Recommendation Report for Planning Permission for Works or Extension to a Dwelling

REF NO: R/36/19/HH

LOCATION: 12 Central Avenue
Rustington
BN16 2HG

PROPOSAL: Roof alterations with raised roof ridge, first floor side extension and front and rear dormer windows

Proposed Side Elevation 1:100
North

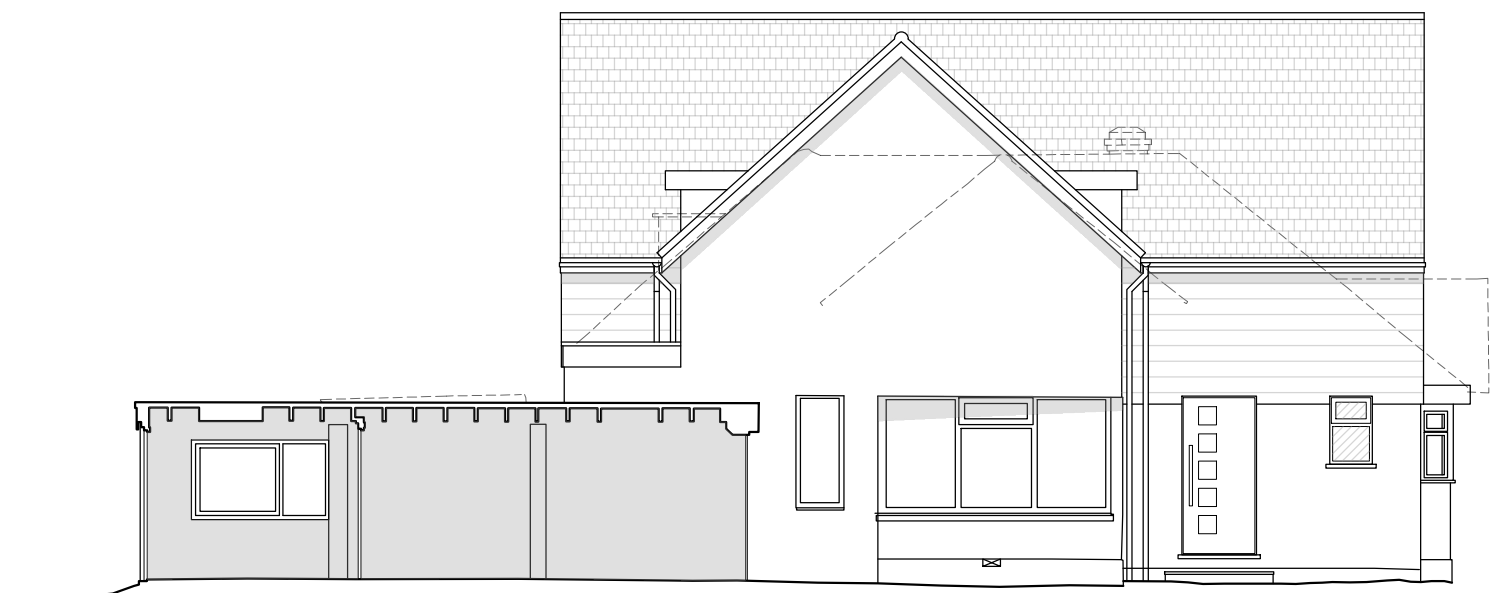
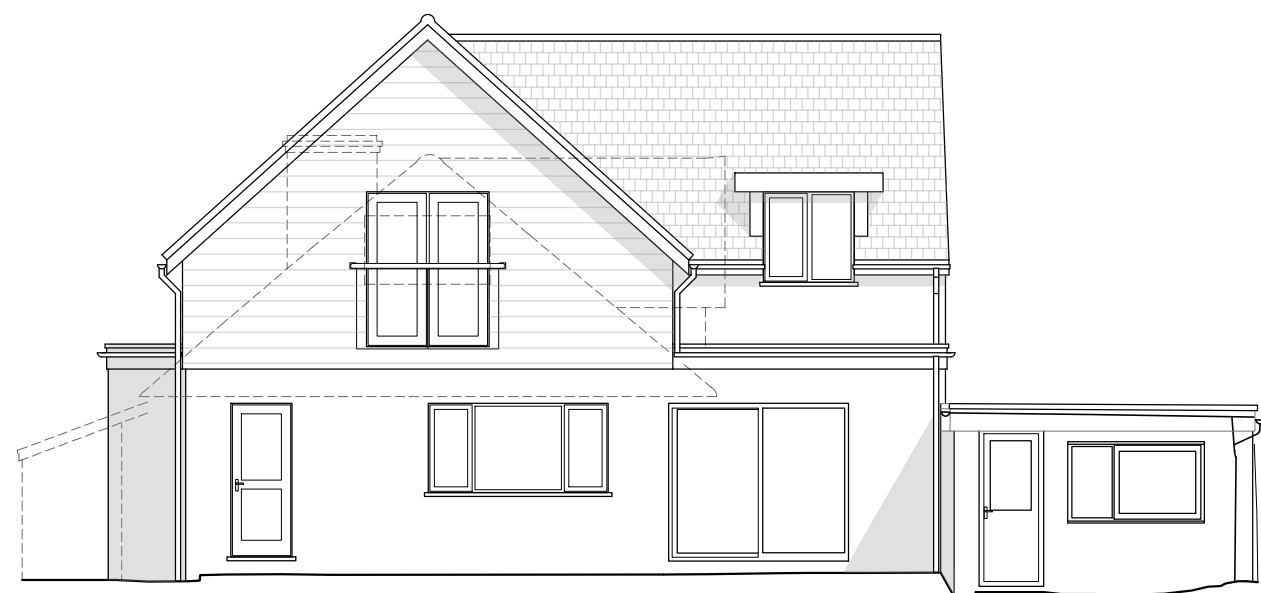
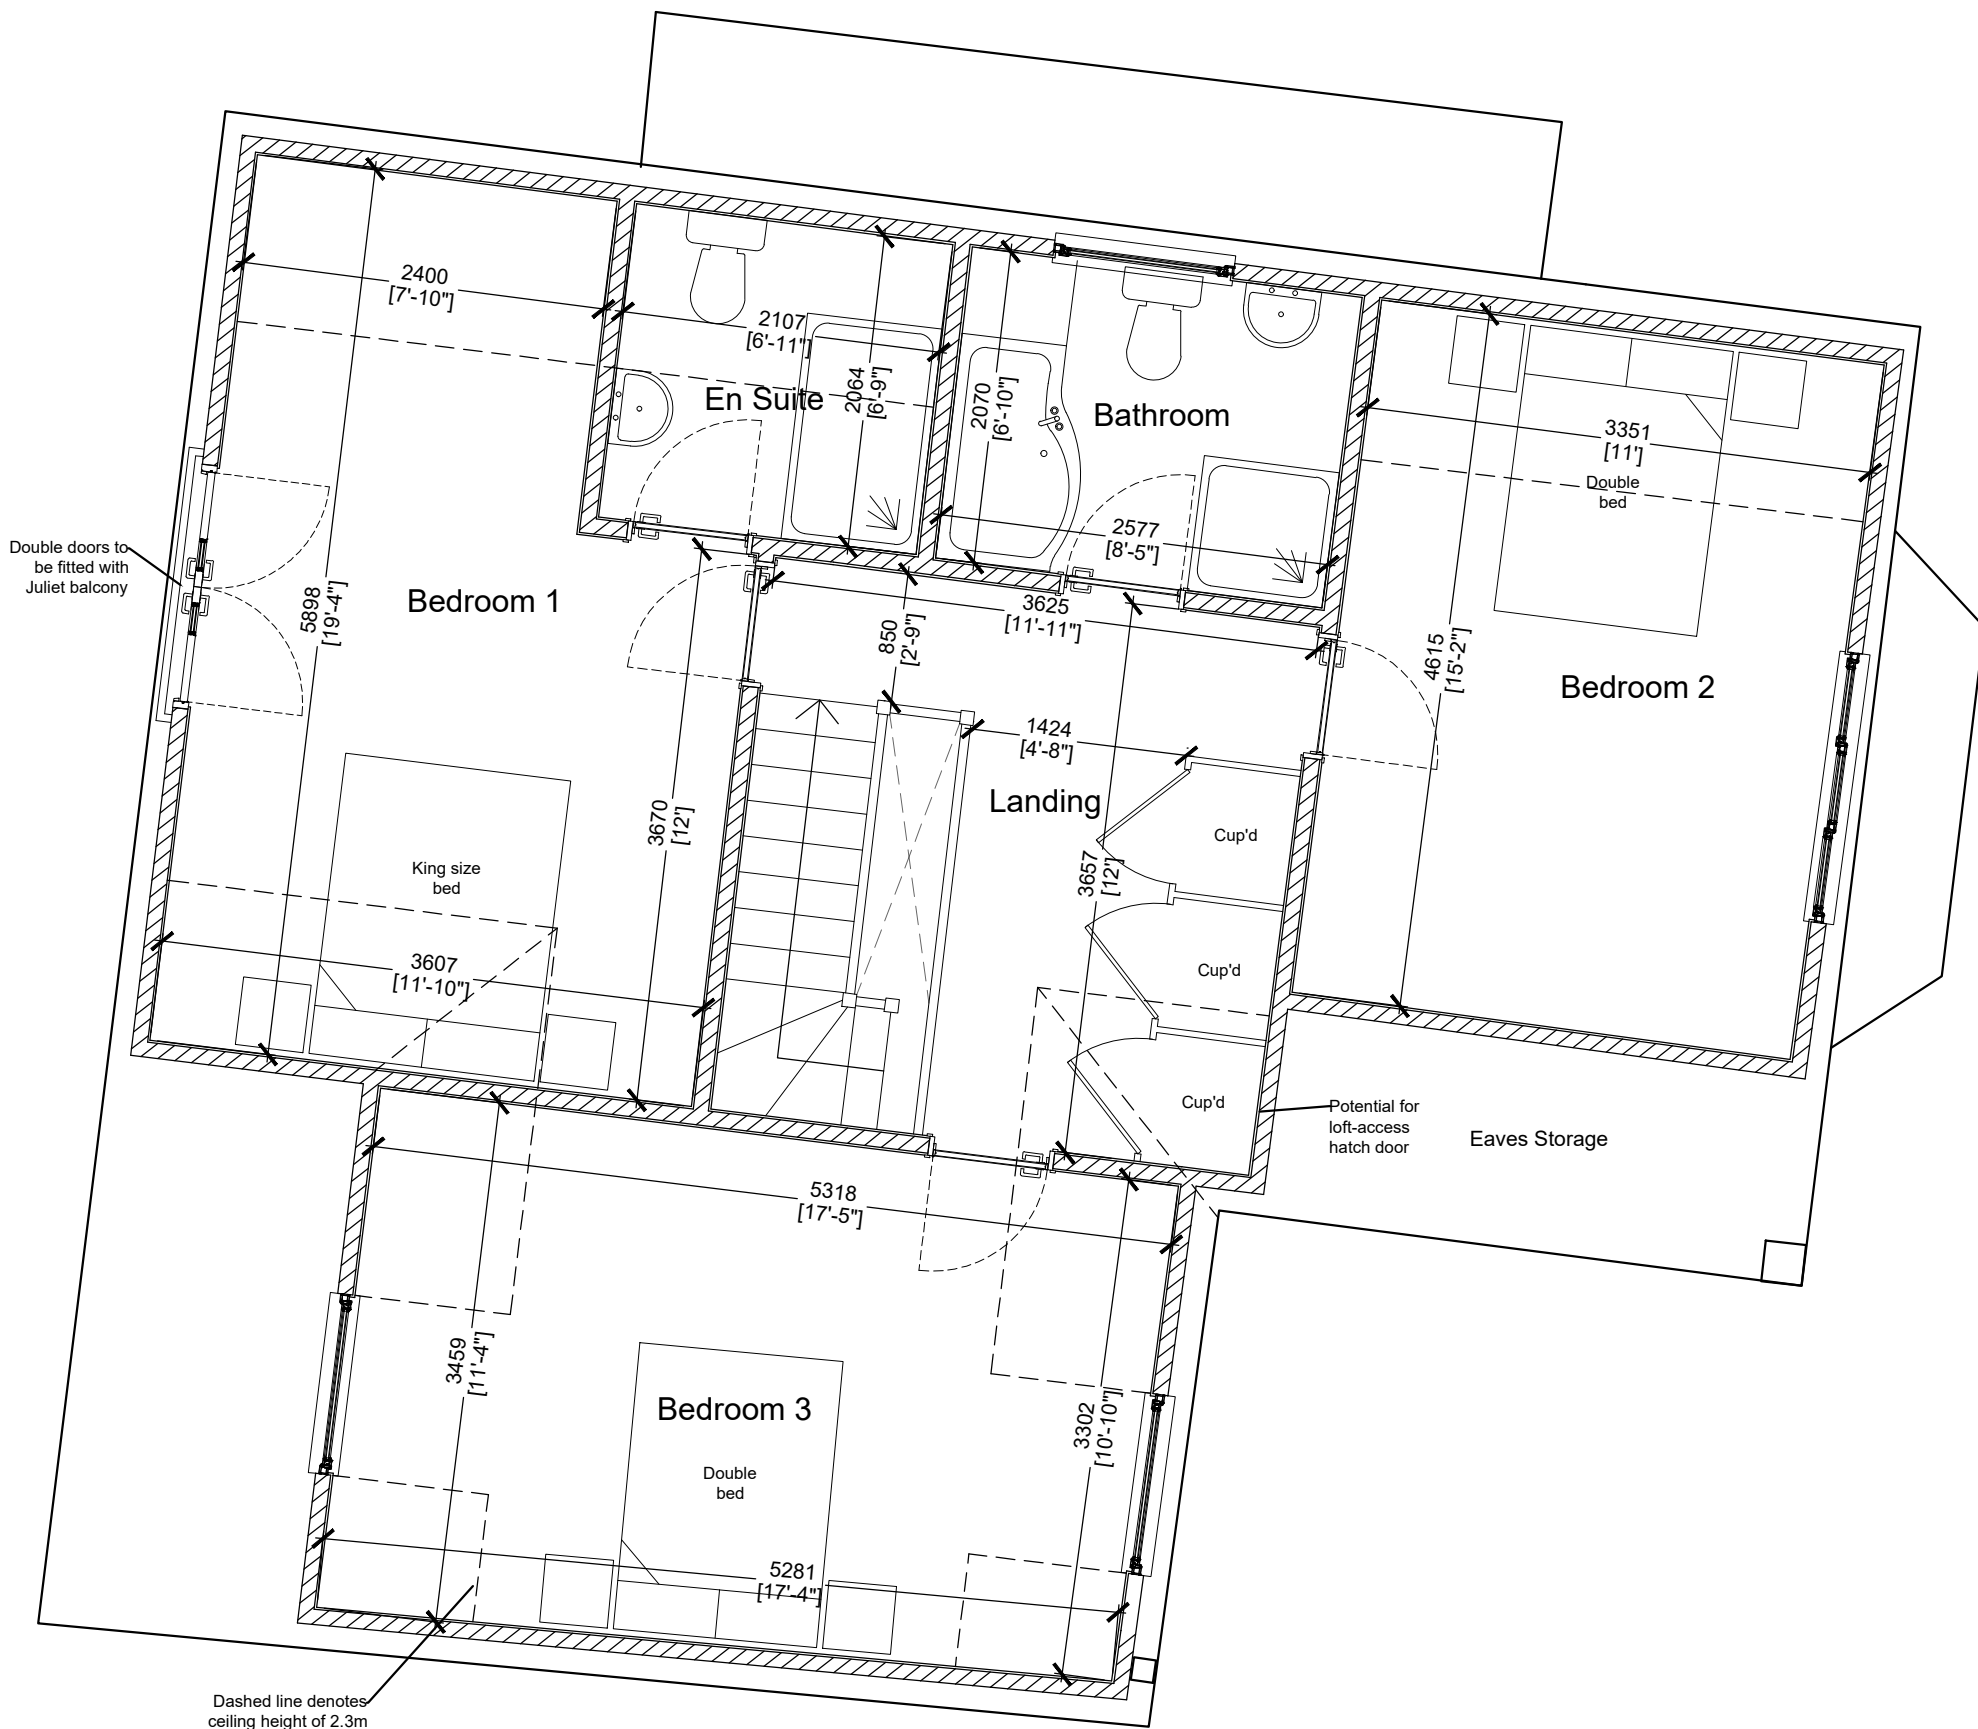
1 letter of no objection:
- The proposed first floor windows on the Northern side of the proposal will overlook the neighbour to the North.

It is noted that there is potential for overlooking, a condition will be imposed that ensures that these windows will be obscure glazed and non-opening below 1.7m in perpetuity.

- 3 The window at first floor level in the Northern elevation of the building shall at all times be and remain glazed entirely with obscure glass and be fixed to be non-opening below 1.7m, in perpetuity.
